From: Andrew Knowles [REDACTED]
Sent: 28 November 2017 09:55
To: Simon Davis
Subject: Re: 14 Princess Avenue, Bognor Regis - AW/328//17/OUT

Revised ground floor plan (03C) and elevations (06D) attached. Extending Flat 2 has changed the internal floor areas so I also attach amended internal floor area calculations.

Drg No.: SBS/221/06C

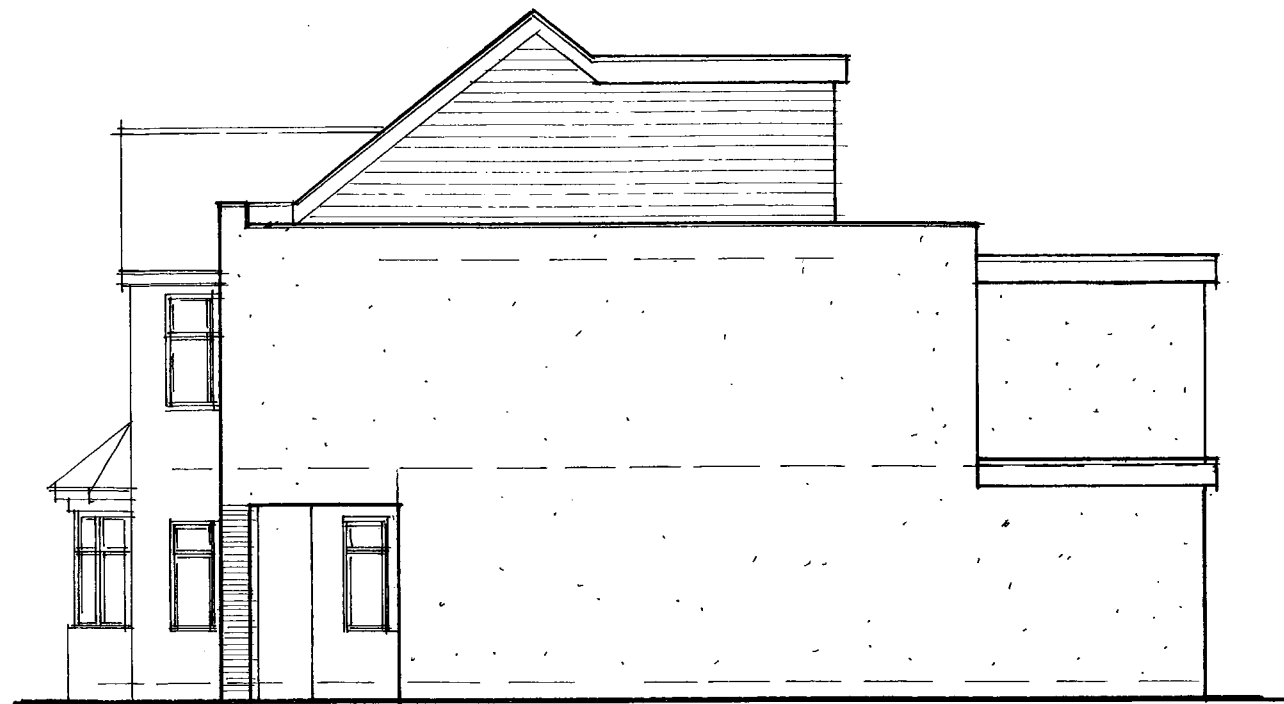
I previously asked that the proposed north facing roof level bedroom window be either obscure glazed or with a sill level of 1.7m. Could you amend the elevations drawing to show this?

Yes no problem I will show it as obscured glazing. Before I send an amended drawing can you take a look at the attached plan.

Drg No.: SBS/221/03C

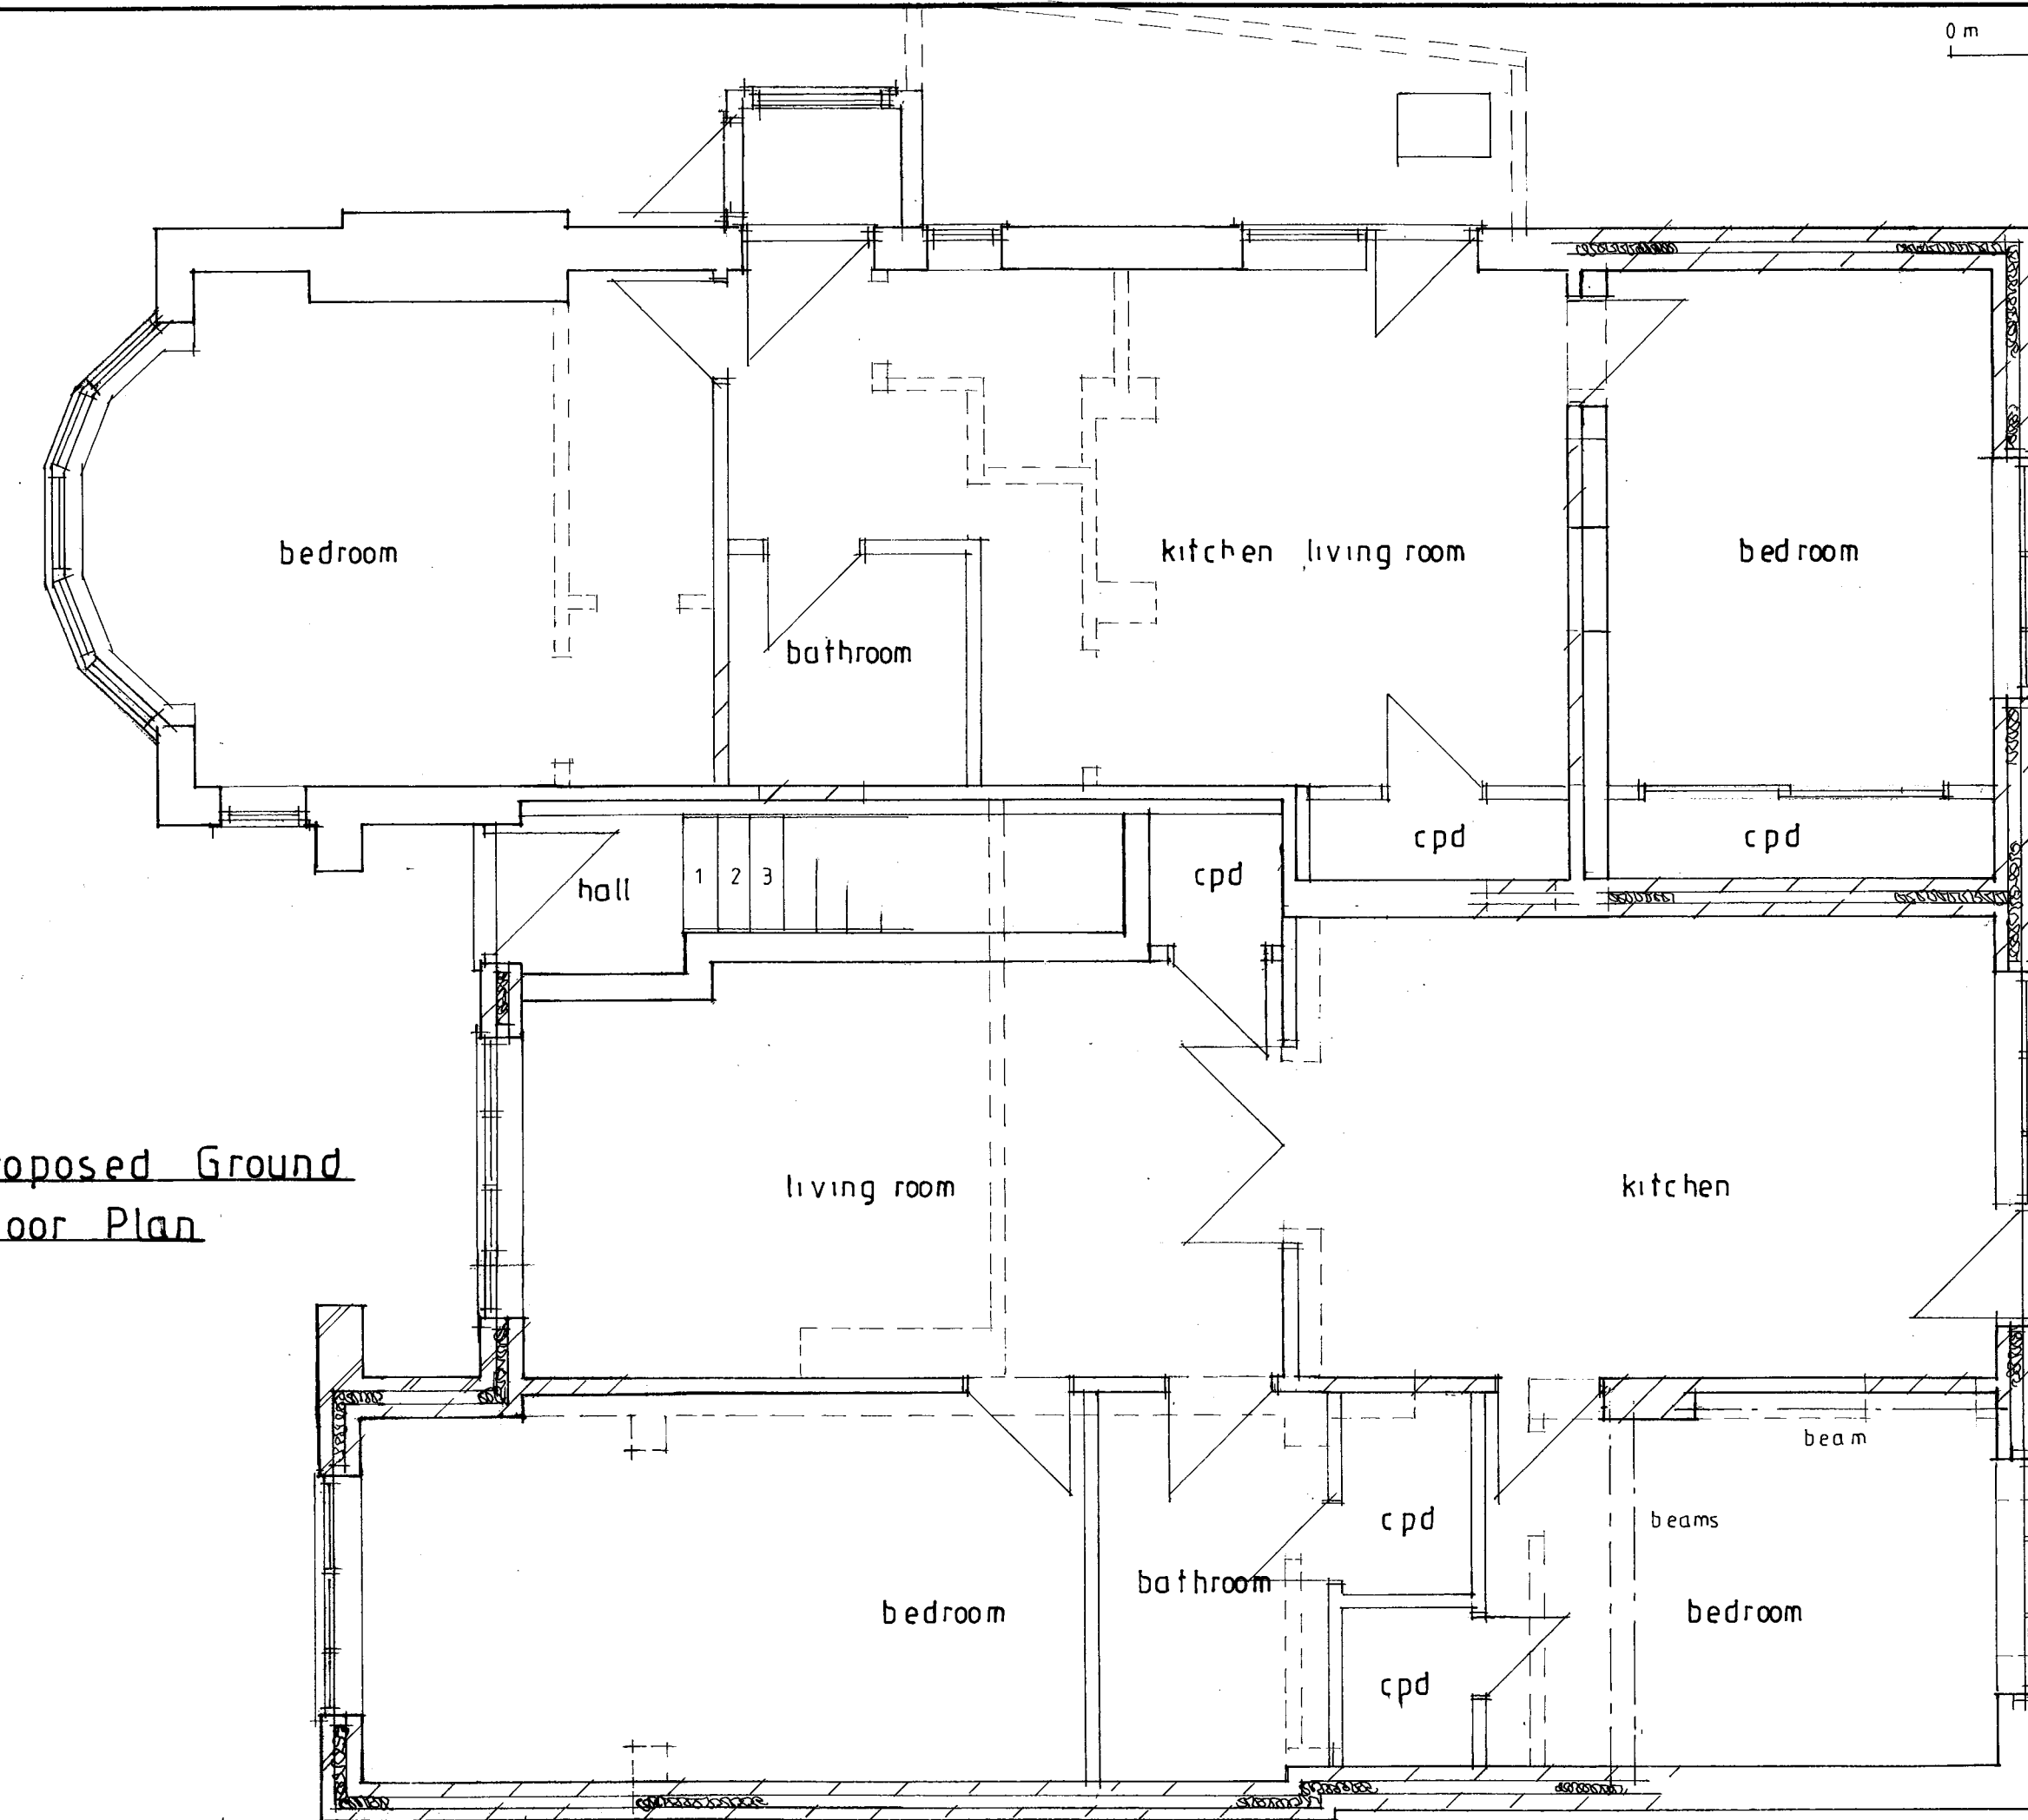
I note that the infill will be below an existing proposed first floor extension. As such, I can support the change. However, fyi only, I will need to advertise the change and as I put the notices up last week, I will need to post new ones.

The client would like to enlarge bed 1 to Flat 2 as shown in red. Can you let me know if this will be acceptable. If so I'll send amended plans and elevations, if not I'll send amended elevations in respect of the northern roof window only.
